From: [REDACTED]  
To: [REDACTED]  
Cc: [REDACTED]  
Subject: FW: Joanne Wren RE: Invalid Letter 23/01908/F  
Date: 03 November 2023 09:49:09

This email is in response to the Invalid letter received for the planning application: "Installation of 130kWp solar PV ground array for generation and consumption of electricity at the farm at Park Farm Castle Road Wormegay KINGS LYNN Norfolk"

Scale NTS	Size A4	Project No. 109953	Drawing No. PA03	Rev A
--------------	------------	-----------------------	---------------------	----------

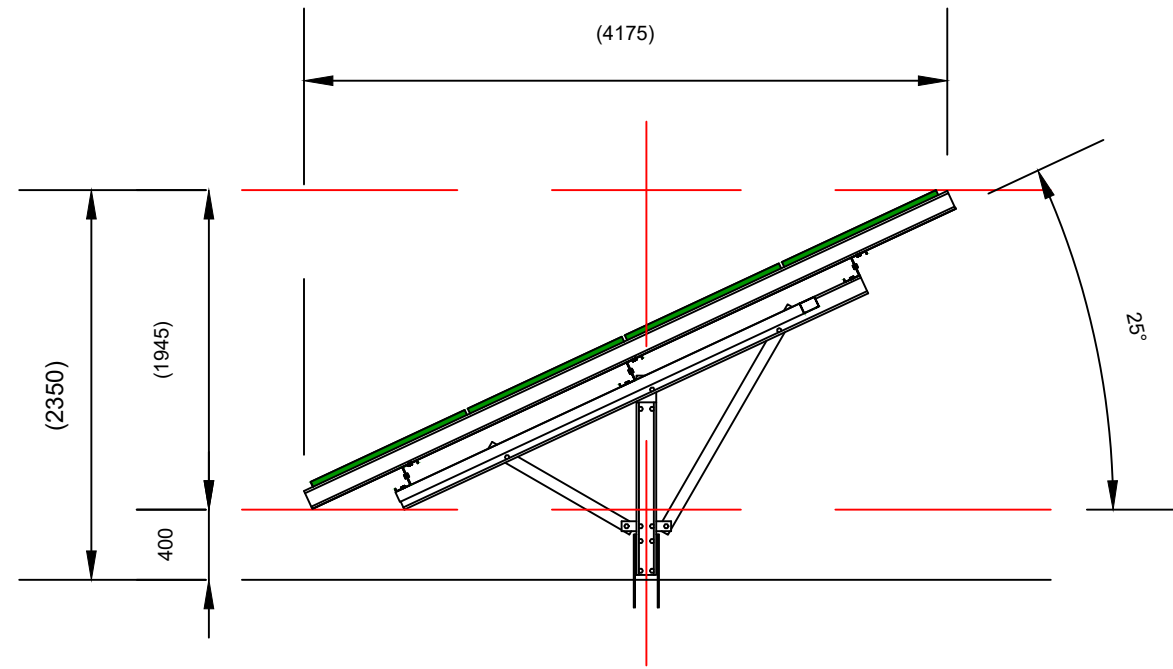
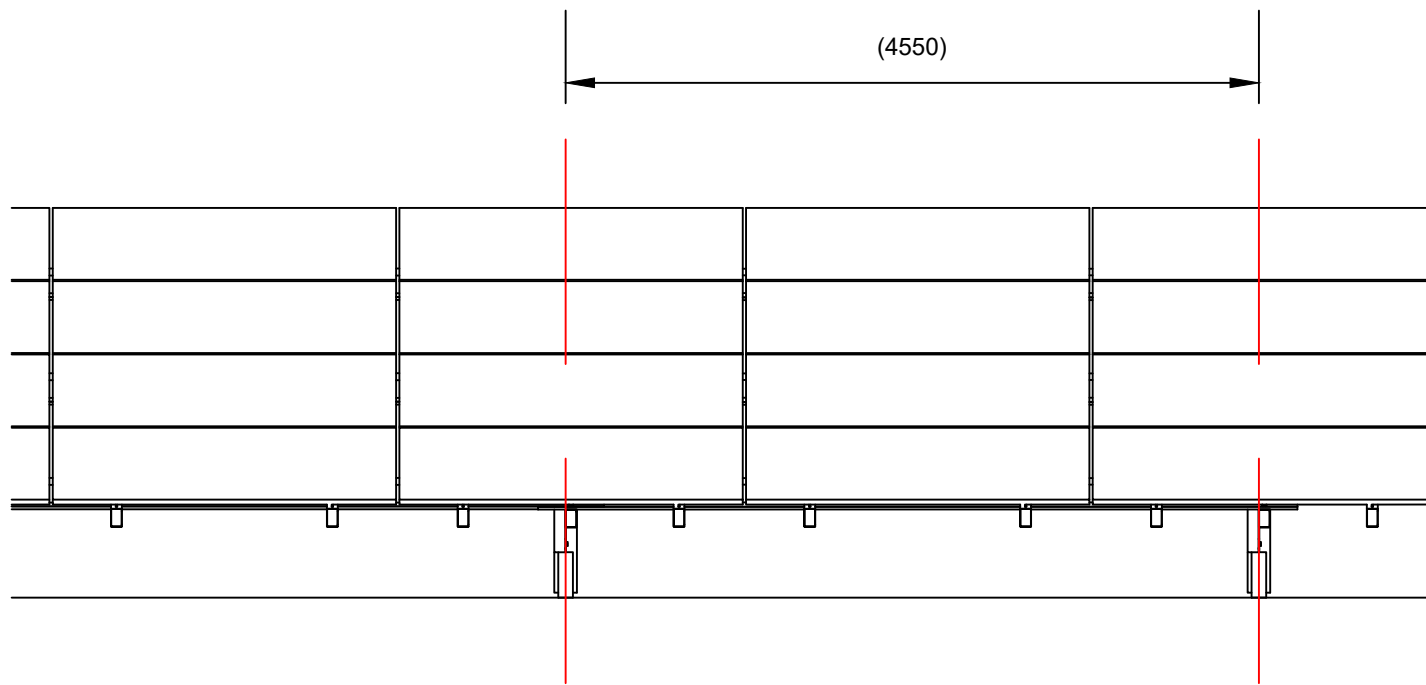
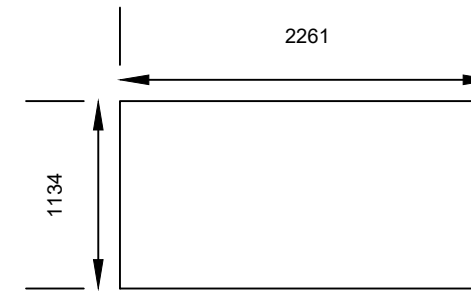
Also it appears that we are pending amendment to a drawing No. Pa03 A, where annotation states: do not scale off this drawing, please remove this annotation, please also state what scale it is drawn to, so we can measure the drawing.
